LOCAL CENTRE PLANNING APPLICATION CONSULTATION COMMENTS SUMMARY 15/00760/F

Statutory Consultee	Comment	Consultant Team Response
Bioregional	<p>Building footprint/GIA</p> <ol style="list-style-type: none"> 1. P6 Table 3.1 provides the proposed non-residential uses in the local centre. The total GIA of these uses adds up to 3,066 m², 350 more than the 2,716 m² stated. The Energy Centre GIA appears to have been omitted from the total. 2. No assumptions are provided for translating the total floor area of building types to GIA in table 3.1. Different land uses have different ratios of GIA to Total Area, presumably due to outdoor space and multi-storey buildings. It would be helpful if the assumptions were stated. 	<p>Response issued to CDC in w/c 13 July 2015.</p>

PUBLIC PARKING	(37)
ECO BUSINESS PARKING	(23)
STAFF PARKING	(23)
TOTAL	(83)

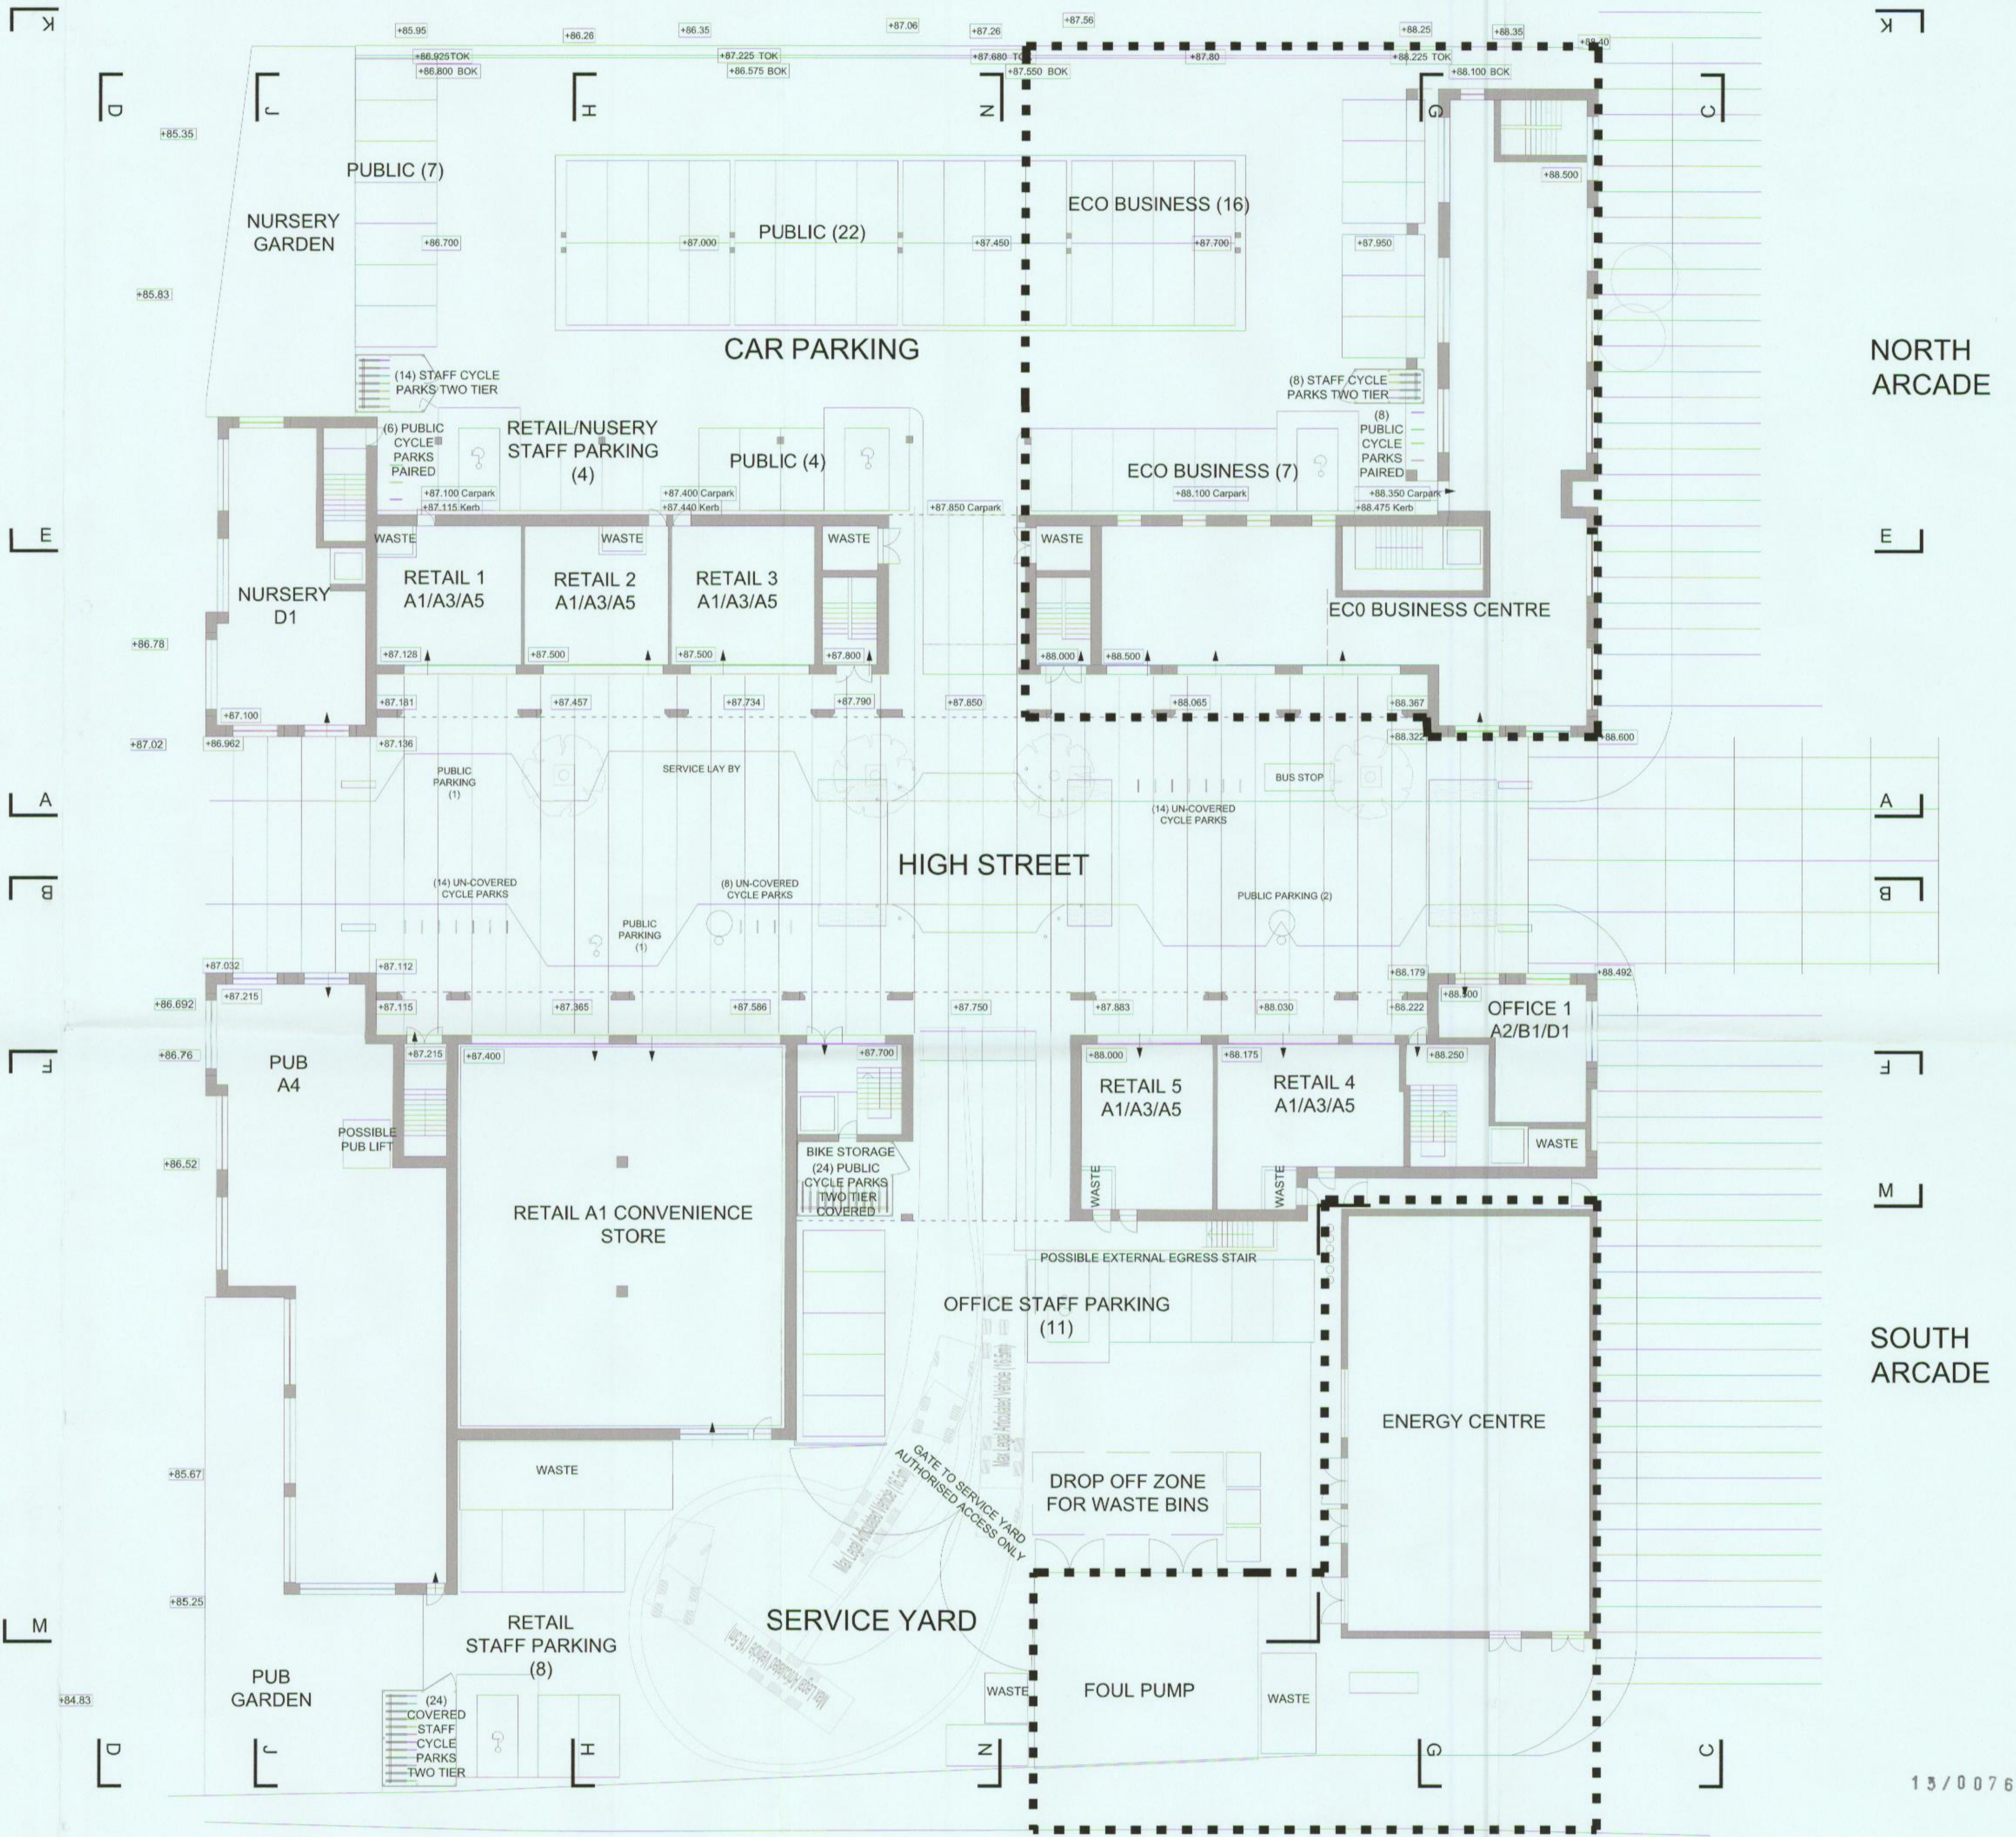
<p>measures, OCC has concerns that in reality parking would not be adequate and inappropriate overspill parking would be a problem.</p> <p>A total of 37 spaces are proposed to be available to the public, with the remaining 46 allocated for staff at all the various uses. The CDC max parking standard for the Eco Business Centre and Nursery (which would be very largely intended for staff) alone would be 84, so there is a significant risk of all-day staff parking spilling into the public parking spaces or into nearby residential areas. The Travel Plan states that there will be a 'need for a strict parking management regime' and 'enforcement of inappropriate overspill parking' but no details are provided in the TA. It is also not clear in whose ownership the car park will be. Further details including a parking management scheme will be required.</p> <p>Uses other than the Eco Business Centre and Nursery are likely to have demand at the same time, albeit the peaks may differ. Staff taking up spaces for customers/users of the pub, community centre and shops will add to the pressure on spaces for daytime users and people</p>

dropping children off at the nursery.	
Oxfordshire County Council	<p>Car Parking Size</p> <p>Parking spaces should be 5m x 2.5m – they appear shorter.</p>	In the amended layout plan (revision 14058 (P) 101 Ground Floor Rev N), 5m x 2.5m parking spaces are shown.
Oxfordshire County Council	<p>Car Sharing</p> <p>The Travel Plan says there would be car sharing spaces but OCC cannot see any of these.</p>	We propose that the allocation of car sharing spaces be dealt with in the Parking Management Plan.
Oxfordshire County Council	<p>Cycle Parking</p> <p>There appears to be confusion over 'stands' and 'spaces'. The cycle parking standards set out a requirement for stands, and are clear that one stand equals two spaces. Therefore on the basis of the cycle parking standards, the overall proposed provision is inadequate.</p> <p>The Travel Plan states that cycle parking would be of the Sheffield stand type. All of the staff cycle parking, and some of the visitor parking is in rack arrangements, some double deck. This is not considered appropriate for visitor cycle parking, given its short term nature, the variety in types of user and the fact that it would</p>	<p>The cycle space standards applied in the Local Centre Transport Assessment are based on provision for each land use as a stand-alone development. This leads to requirement for 100 stands or 200 cycle spaces. There will, however, be considerable numbers of linked trips within the Local Centre, with users of the community centre also visiting the convenience store for example. This relationship is included in the trip generation calculations. As such it is considered that the provision of 120 cycle spaces serving the local centre as a whole is expected to provide sufficient cycle parking. We recommend that the demand for cycle spaces is monitored as the local centre builds out and additional stands are provided if required.</p> <p>The Transport Assessment lists the provision as stands in line with the standards, as did the original Transport Assessment for the Exemplar. This issue seems to have got confused as original plans referred to 'parking' rather than spaces or stands. The plans now identify spaces.</p> <p>In the eco town, visitor parking on racks may be acceptable as it is becoming more commonplace at stations.</p> <p>The revised layout provides cycle stands such that there will be locations where bikes with trailers can be accommodated</p>
